COUNTY COUNCIL'S RESPONSE TO CONSULTATION ON THE FOLLOWING DEVELOPMENT PROPOSAL

Application No: 20/03353/OUT

Proposal: Outline application for a food store, including access and scale
(resubmission of 20/00123/OUT)

Location: Land West of Cotefield Business Park Oxford Road Bodicote

SURFACE WATER
DRAINAGE STRATEGY

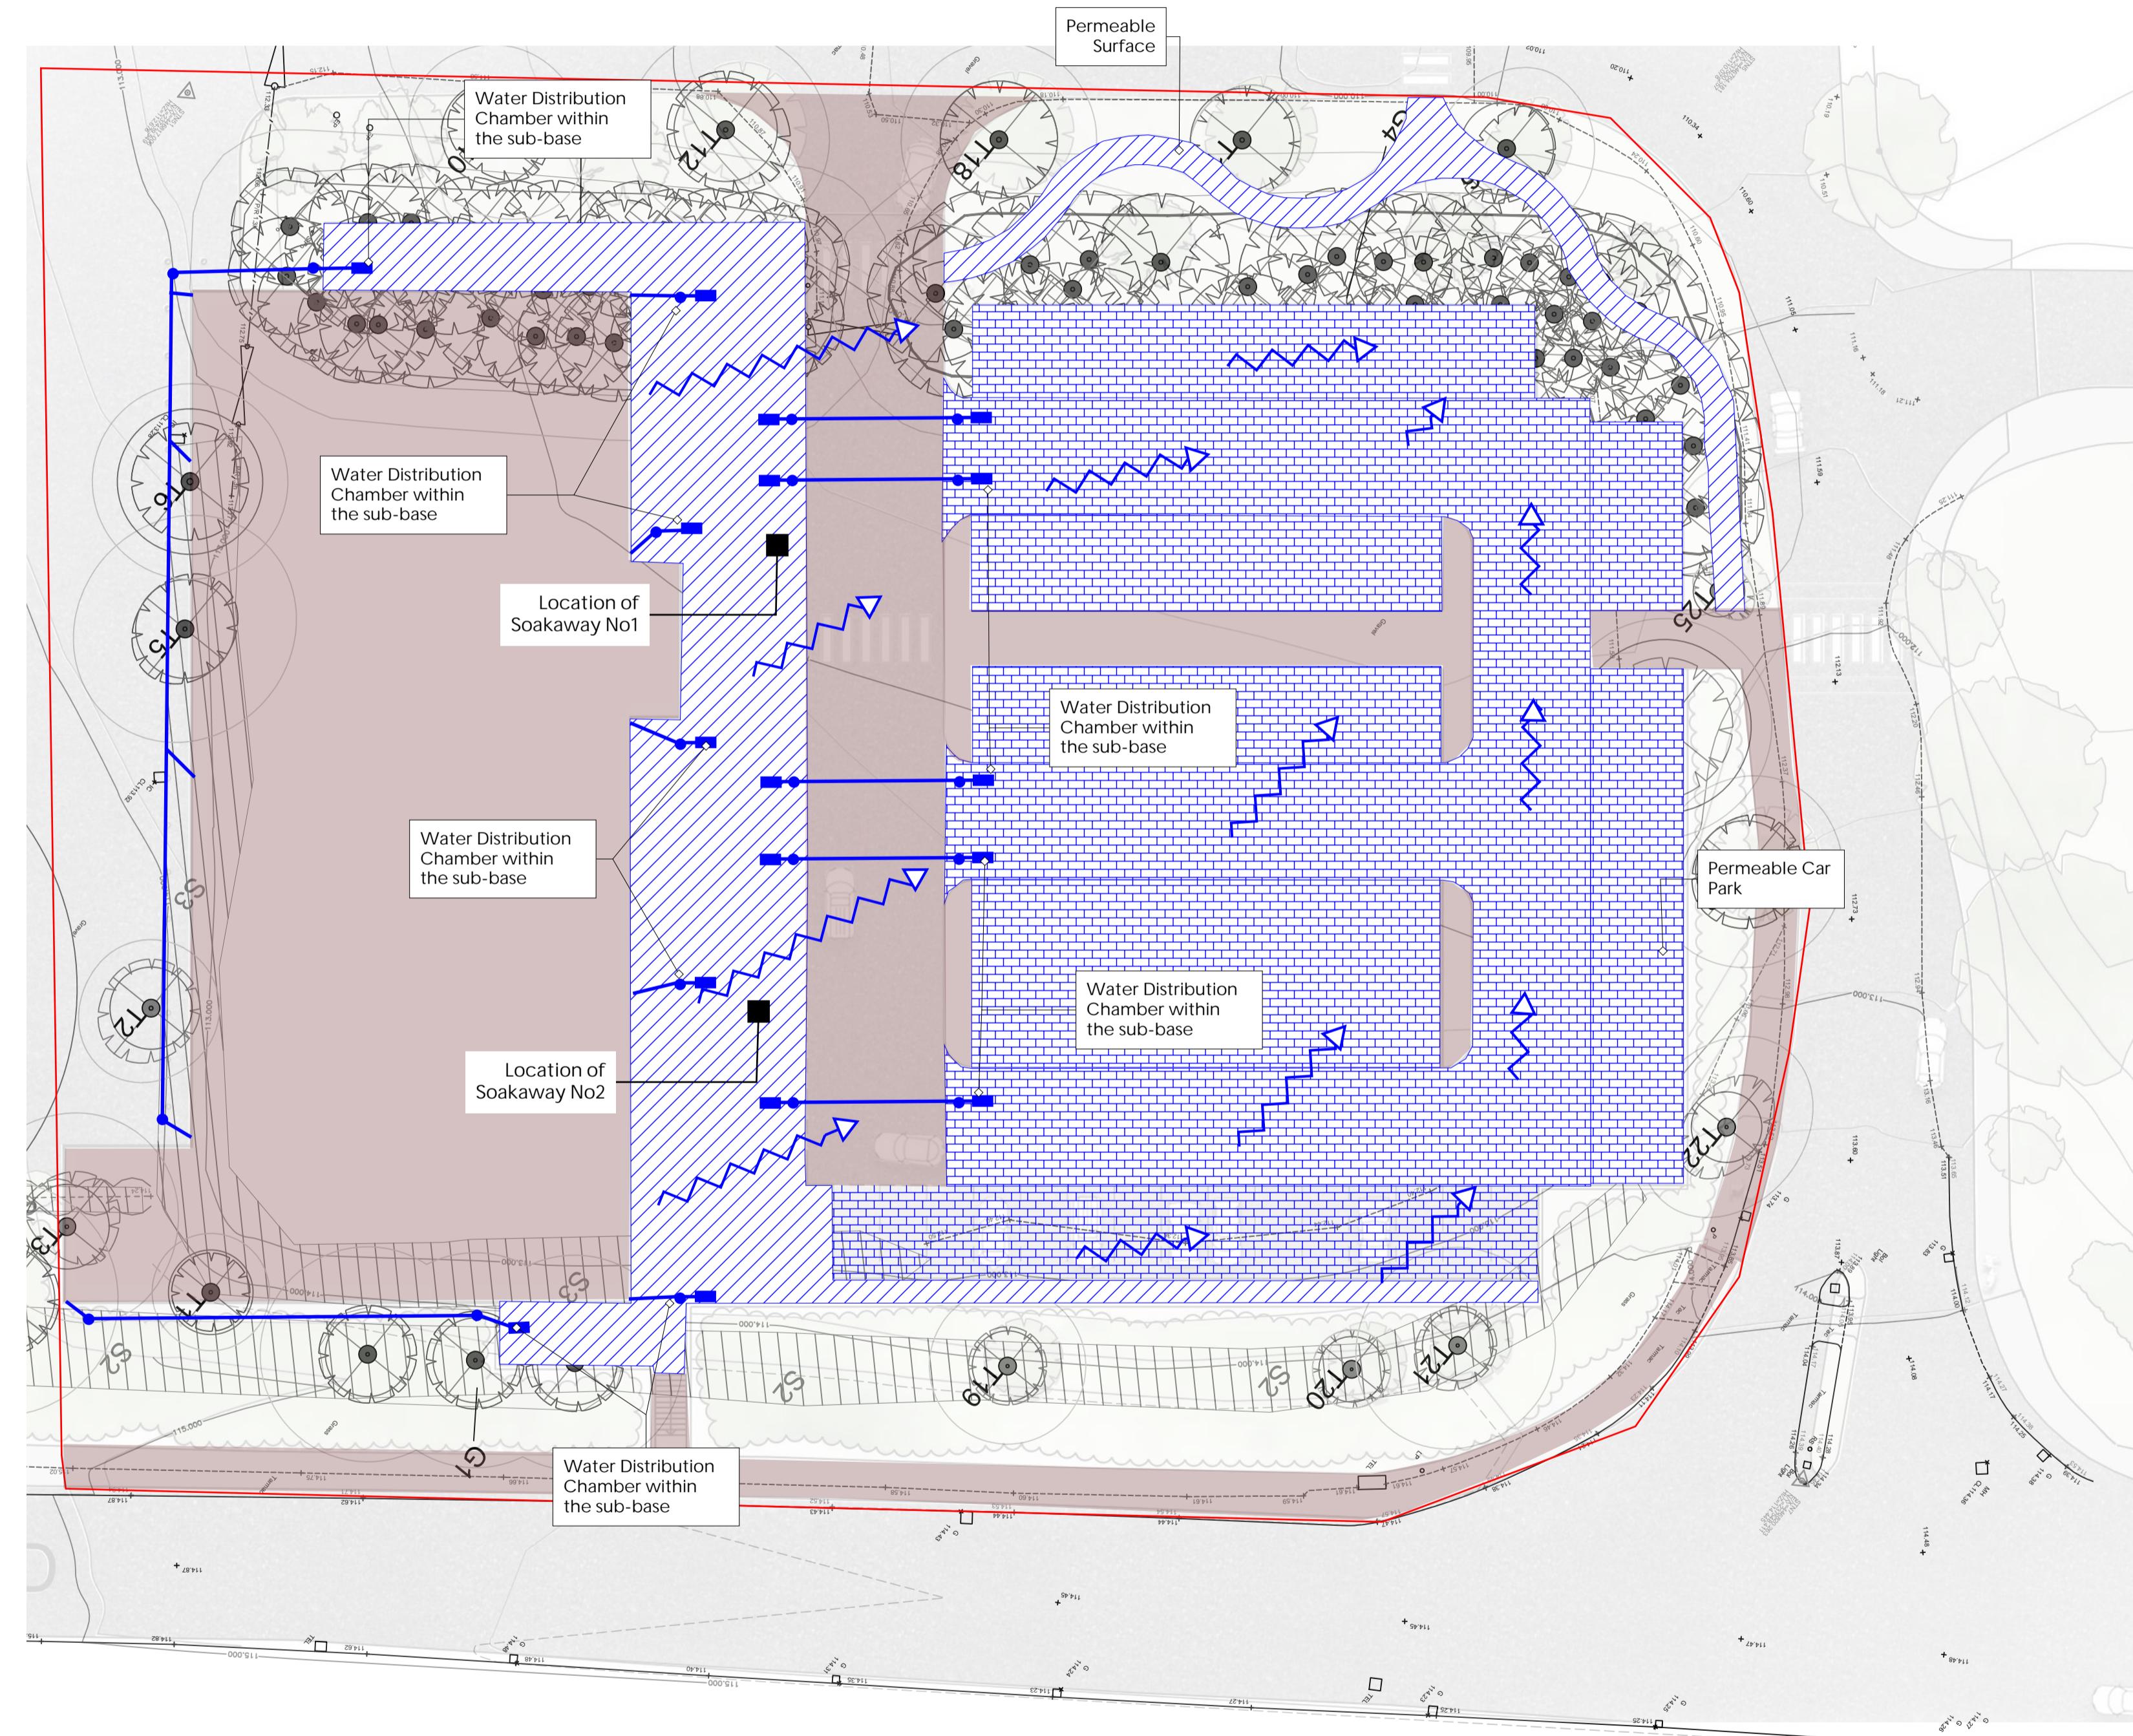
The drawing provided needs to be clearer and more detailed. It needs to show the water quality treatment measures, where proposed infiltrations systems are and exact location of trial pits. Each item should be easy to identify and clearly stated in the drawing key.

Parts of the site are surcharging for 1 in 1 year storm. This will need to be addressed in detailed design.
